Planning Objection: CM/64/19/PL Langford, Horsemere Green Lane BN17 5QZ

Plot 8 deliberate misrepresentation by applicant to ADC

Drawing Title:
STREET SCENES/SECTIONS

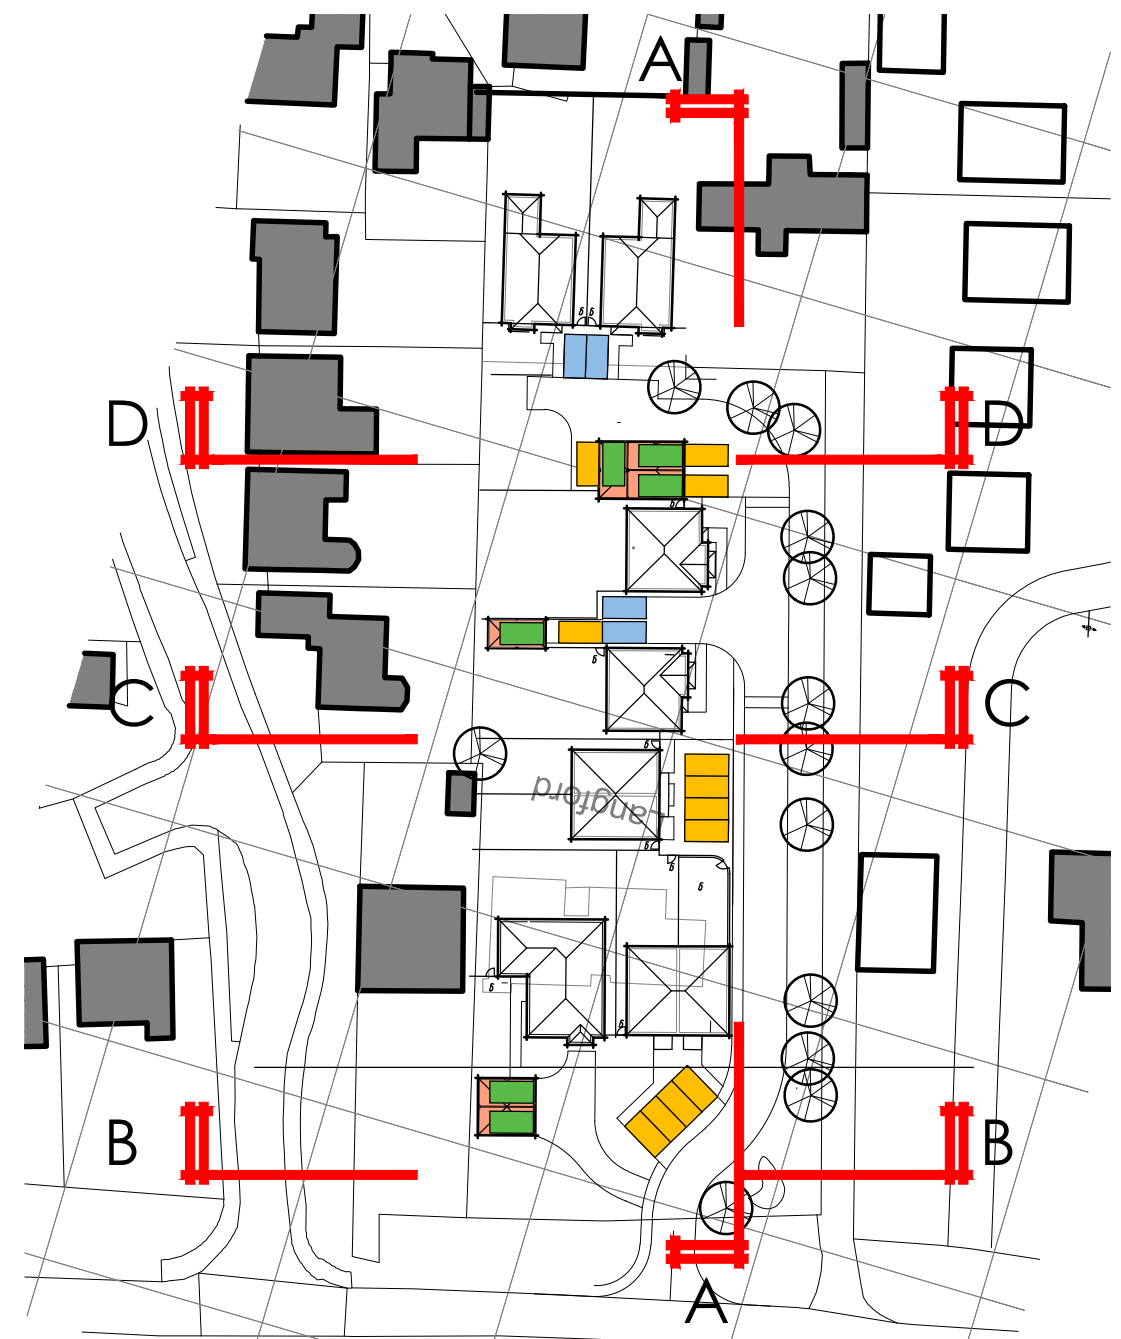
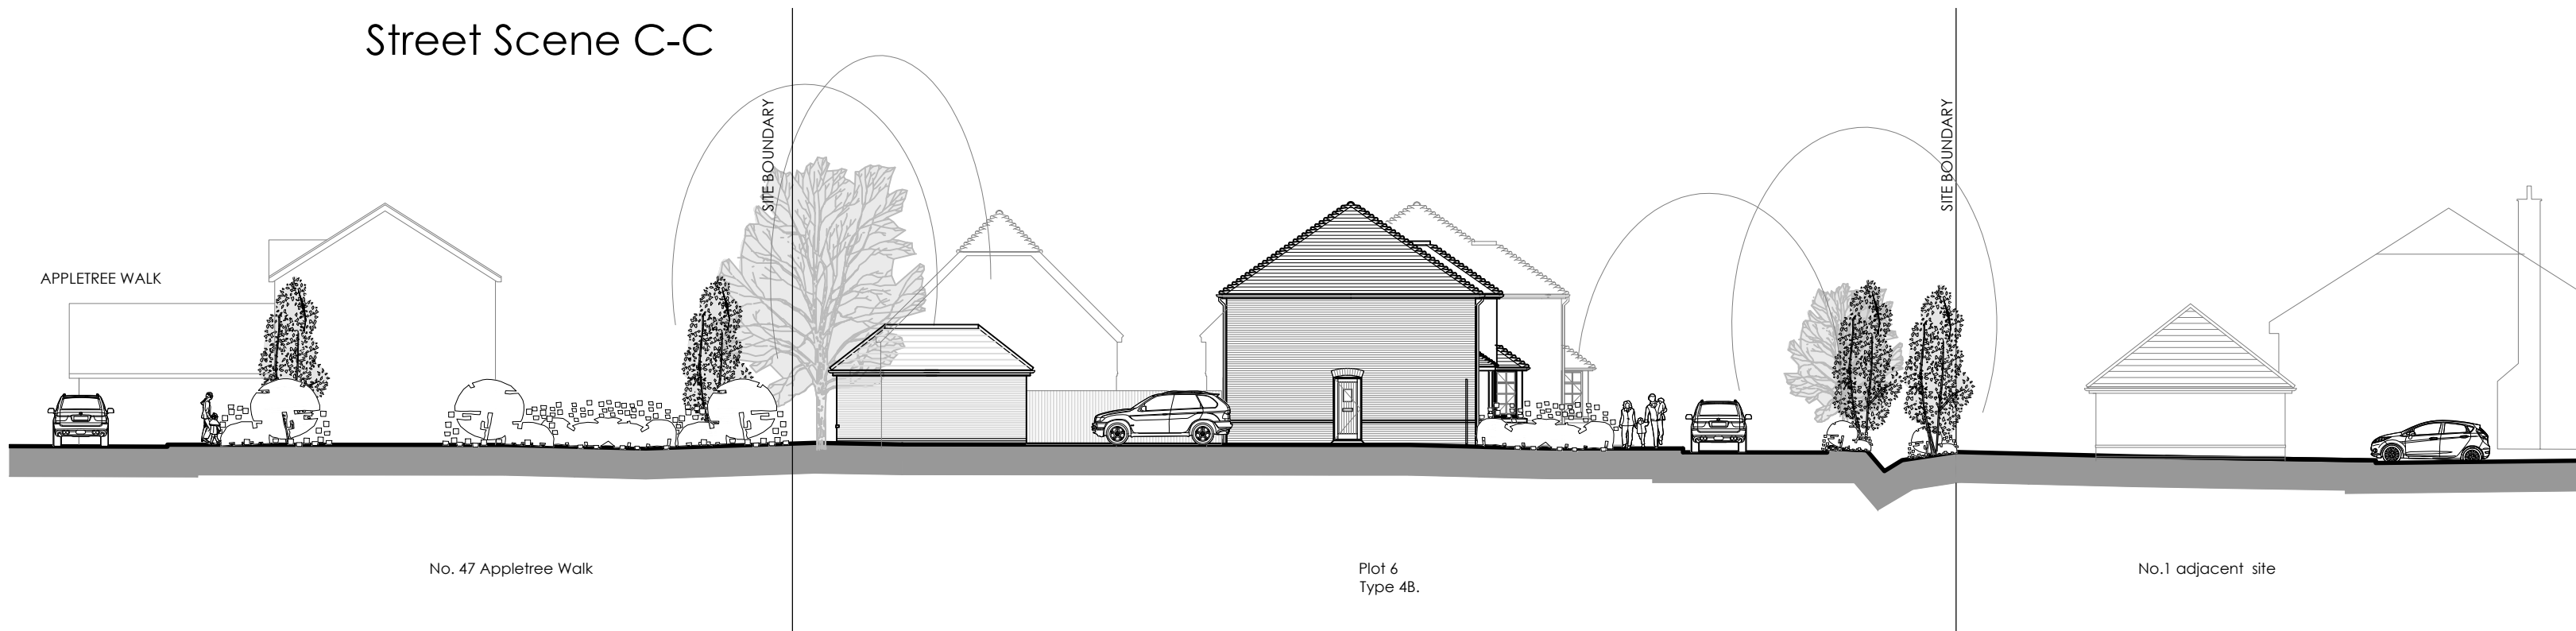
3. The value of my property has been badly affected.
4. PLOT 8 runs the length of my boundary. An application for a 4-bed house type E has been superseded by House type F described as a **3-bed BUNGALOW**. Having looked at the plans this is a **HOUSE** with 2 bedrooms and 2 bathrooms on the first floor, and one bedroom on ground floor. The whole length of the proposed house runs the whole length of my boundary, with permanent structure within feet of my fence. This is very intrusive, and will obliterate light for the majority of the day, completely unacceptable. I speak on behalf of myself and my affected neighbours.

6. If the applicant were to reduce the roof height to single storey, ie, that of a bungalow, as proposed, and lower the ground level, this would fall in line with their proposal of '**2 x 3-bed bungalows**' made to Arun District Council.
